From: Amanda Scholes on behalf of Planning.Responses
Sent: 14 March 2018 08:30
To: Planning Scanning
Subject: FW: Wandleys Lane WA/73/17/OUT

From: Stephen Gee [mailto:Stephen.Gee@westsussex.gov.uk]
Sent: 13 March 2018 15:08
To: Richard Temple
Cc: Planning.Responses
Subject: RE: Wandleys Lane WA/73/17/OUT

Land East of Wandleys Lane, Fontwell – WA/73/17/OUT

- RPA for CAT A* tree to be retained
- RPA for CAT B* tree to be retained
- RPA for CAT C* tree to be retained
- RPA for CAT U* tree to be retained
- Canopy of tree to be retained
- Canopy of CAT B* tree to be removed
- Canopy of CAT C* tree to be removed

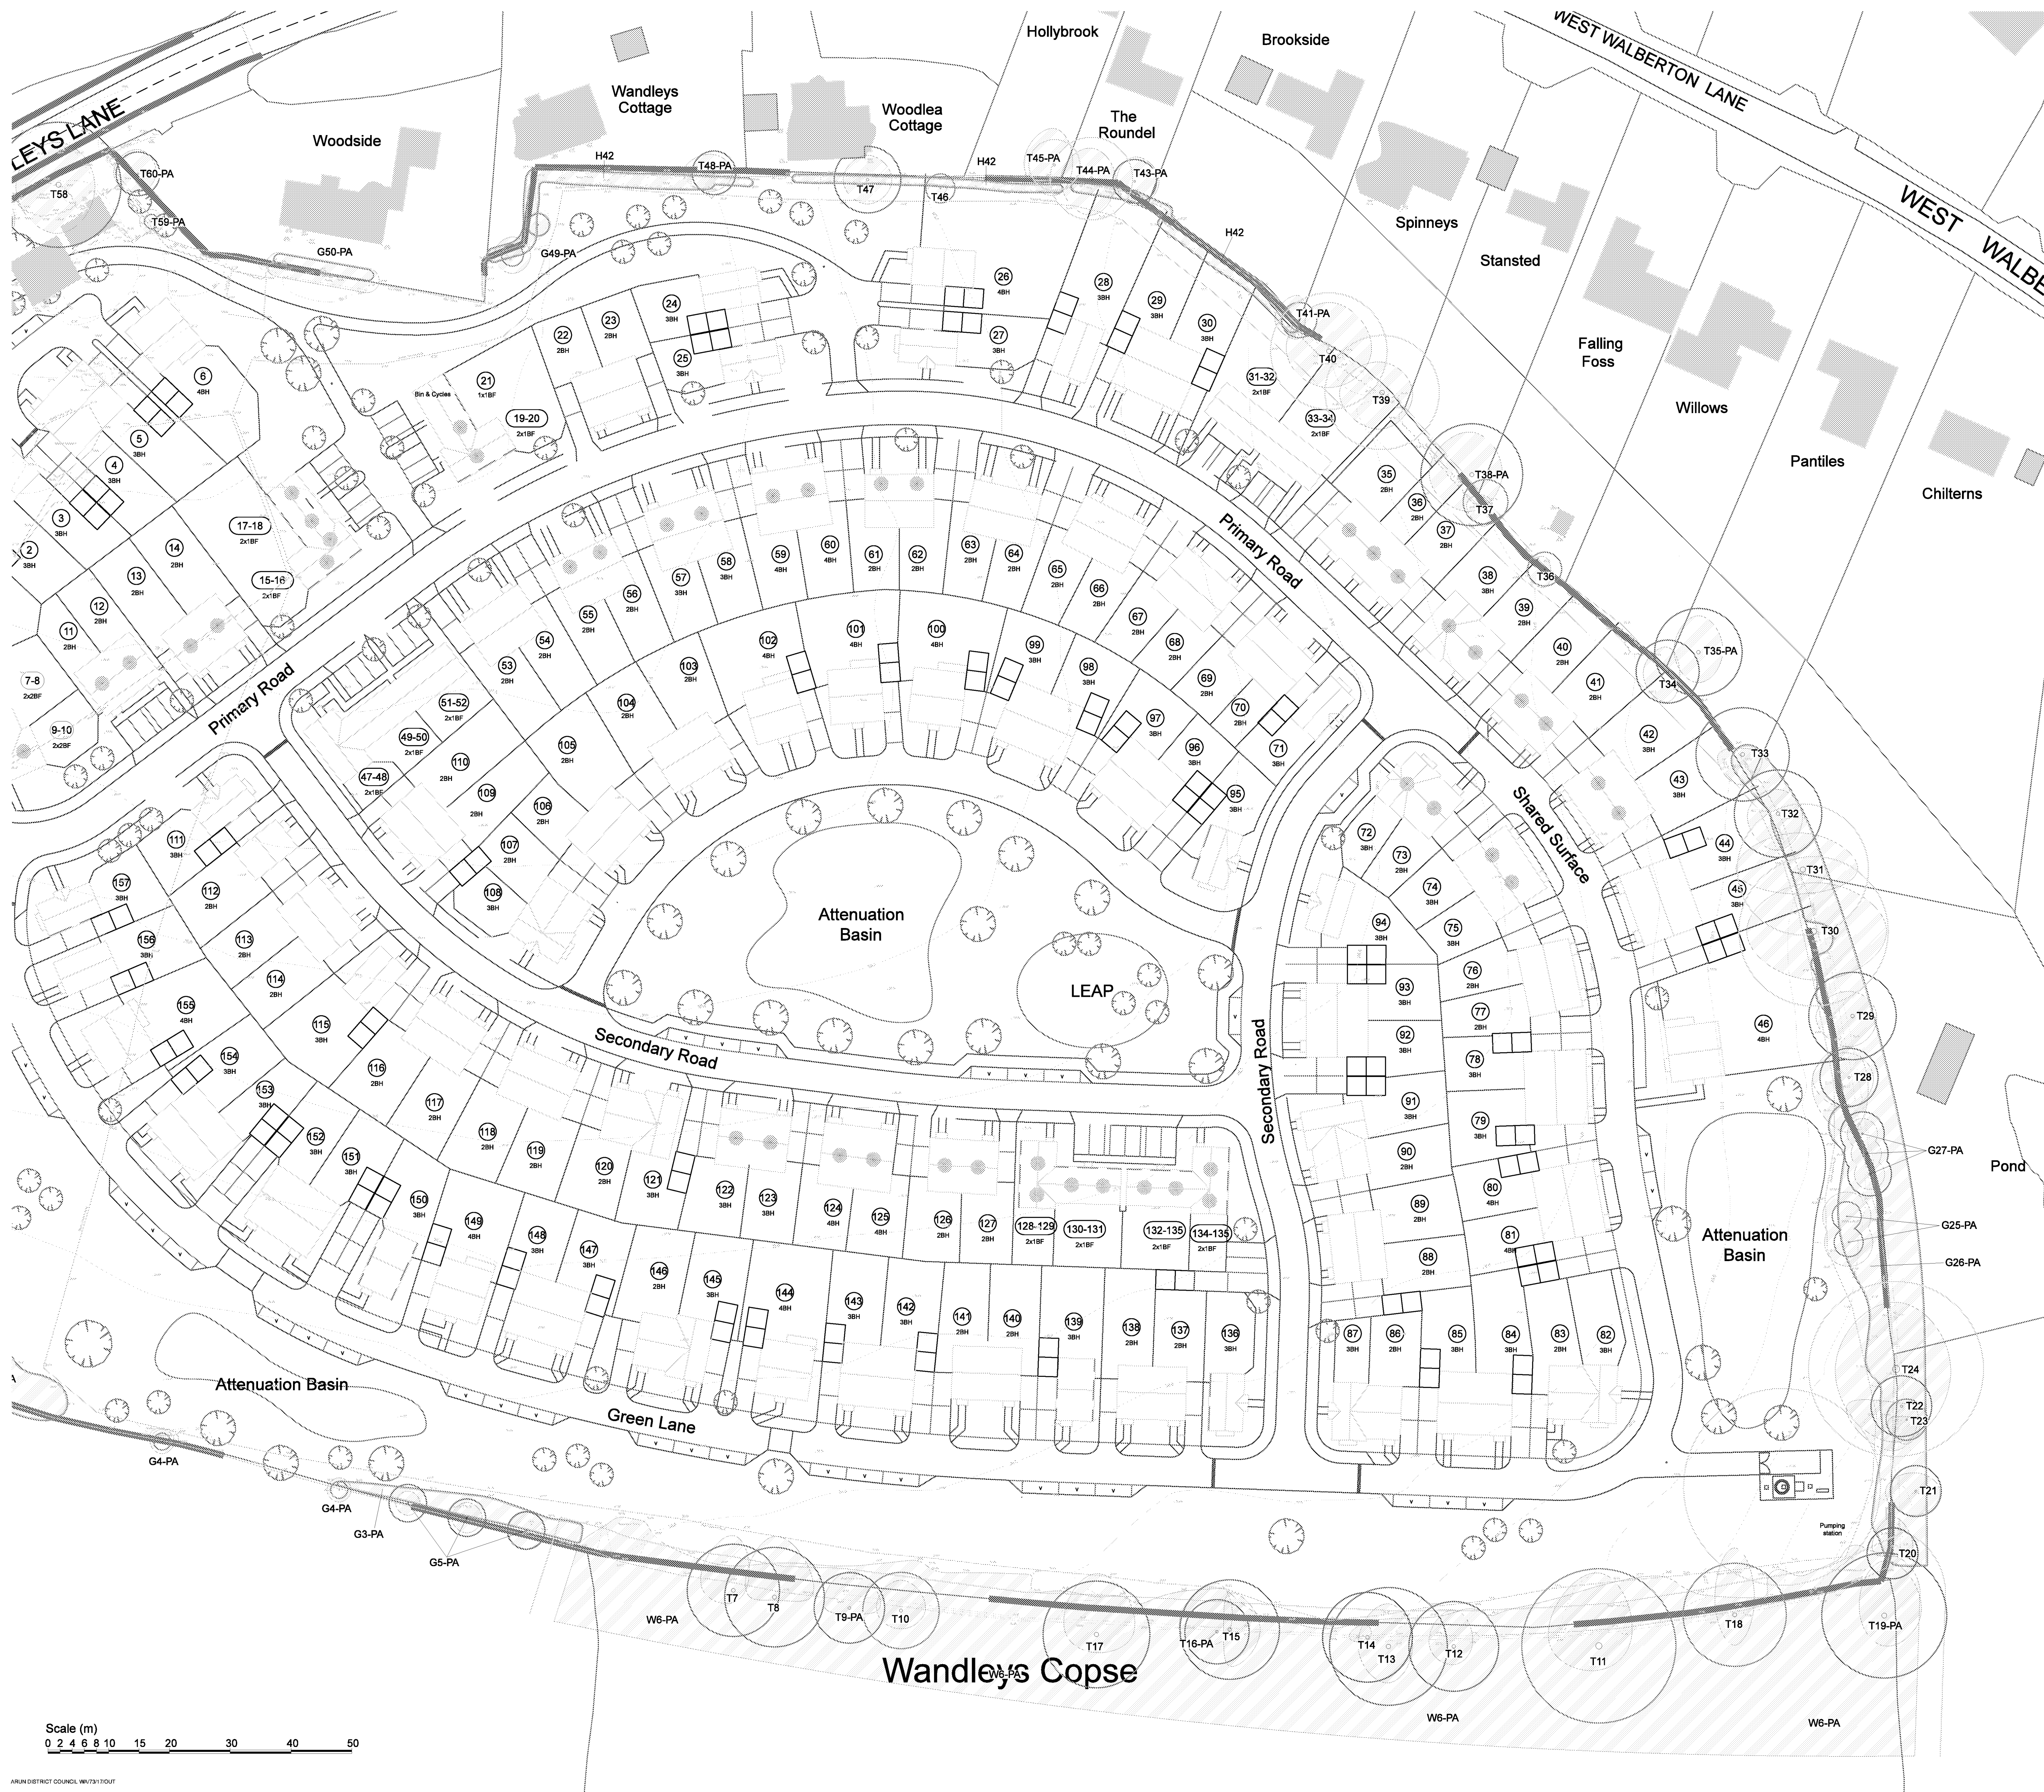
It is not helpful in the tree retention plans for the key to state 'canopy of to be removed' which, if followed literally, could mean the removal of the entire canopy or certainly one side and this isn't what is intended! It doesn't help that the online version of these documents are not in colour.

Sections of the south side of the road are largely hazel coppice. Traditional management is usually by coppicing [i.e. cutting back to the stool every few years] to regenerate and produce useable material; in this case, re-coppicing should be considered to keep the stools viable and to prevent their degeneration over time. If left unmanaged they can eventually split apart. The visual impact of this will be significant in the short term but this is the correct management technique to keep the stools healthy and productive in the long term.

I think H29/30/35 sections are going to be difficult to trim back successfully – particularly any Cupressus element of the hedges – this does not respond well to cutting back hard.

T37 is a category A tree; localised widening appears to be outside the defined RPA, but this is a minimum area so localised excavation by hand / air spade may still be required.
